Application Ref:	3/2026/0165				Ribble Valley Borough Council www.ribblevalley.gov.uk	
Date Inspected:	17/03/2026	Site Notice:	17/03/2026			
Officer:	AR					
DELEGATED ITEM FILE REPORT:					REFUSAL

Development Description:	Proposed erection of detached garage/carport
Site Address/Location:	1 Cockleach Cottages Chipping Road Longridge PR3 2NB

JB 2119
 SITE/ROOF PLAN PROPOSED 1:500 REVISION A
 SHOWING NEAREST TREE

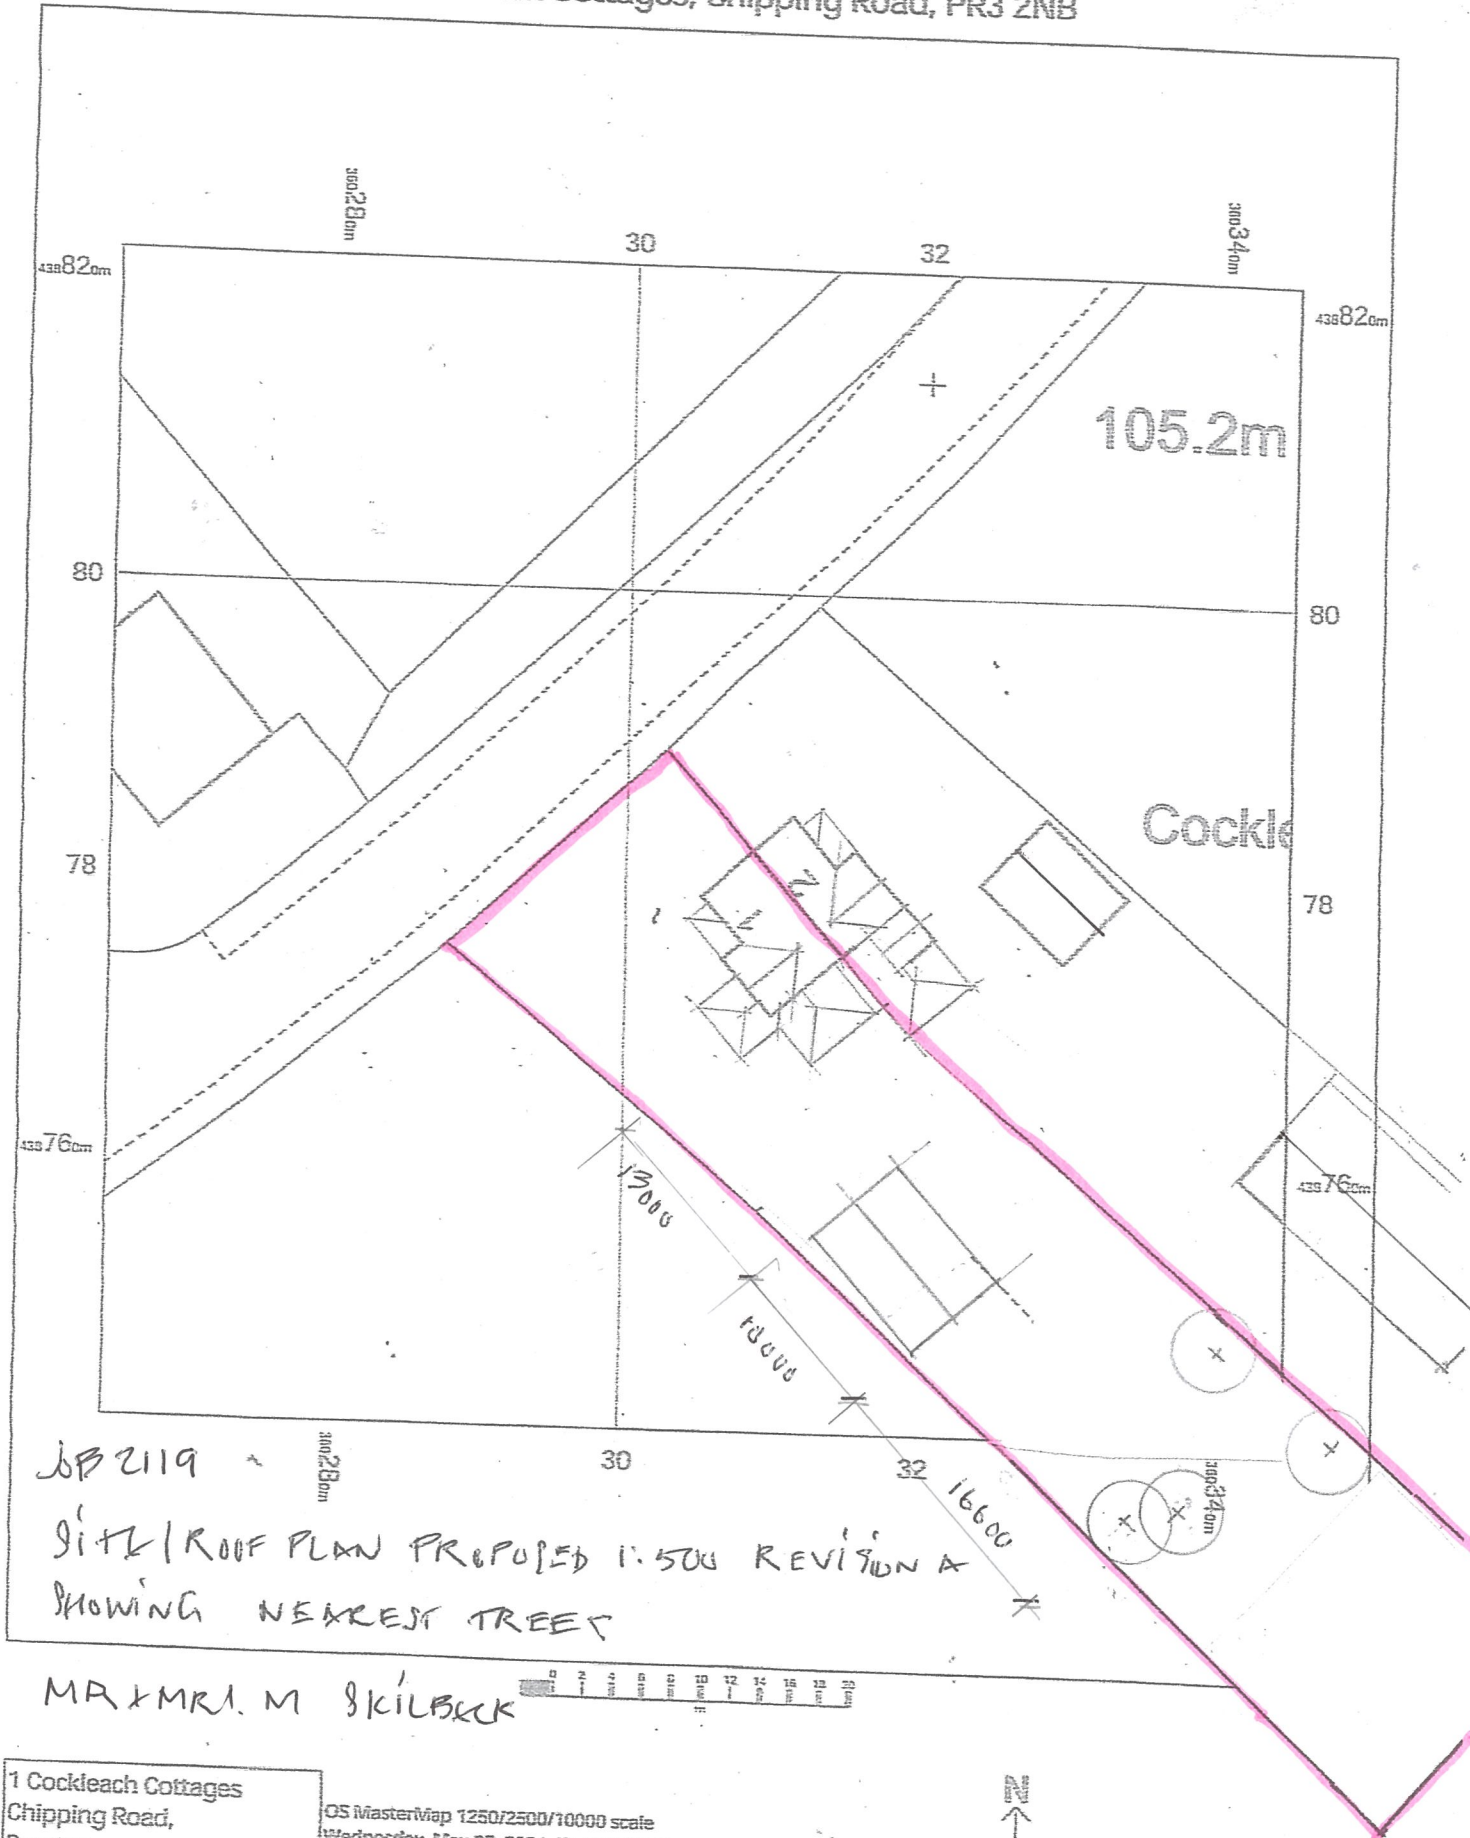
The proposed outbuilding would comprise a substantial footprint measuring 7.5m by 10m with an eaves height of 2.25m and a ridge height of 5.65m, resulting in a building of such a size that the proposed development would begin to visually compete with the host dwelling as a large building in its own right, severely reducing its incidental appearance.

Despite the presence of both a hedgerow and a metal fence along the site's north-western boundary, the existing garage remains visible from Chipping Road, as evidenced by Google Maps imagery and the planning officer's site visit. The current garage has a ridge height of 2.55m, which is 3m lower than the ridge height proposed for the new outbuilding. The proposed development would also exceed the height of the existing outbuildings at No. 2 Cockleach Cottages and, as a result, would appear unduly prominent within the streetscape when viewed from the roadside.

It is understood by the planning officer that the proposed siting of the garage/carport must take into account the proximity of the overhead electricity supply cables and the need for safe, practical vehicular access and manoeuvring, both of which impose constraints on siting. However, due to these constraints and the size and scale of the property, the proposed outbuilding appears detached from the existing dwellinghouse, exacerbating its visual impact.

Furthermore, the footprint of the proposed development is considered overly large, with the building's depth (10m) and roofspan (7.5m) resulting in a total floorspace of almost 75sqm. In this context, the proposed building would not appear as a subservient or sensitive addition to the site.
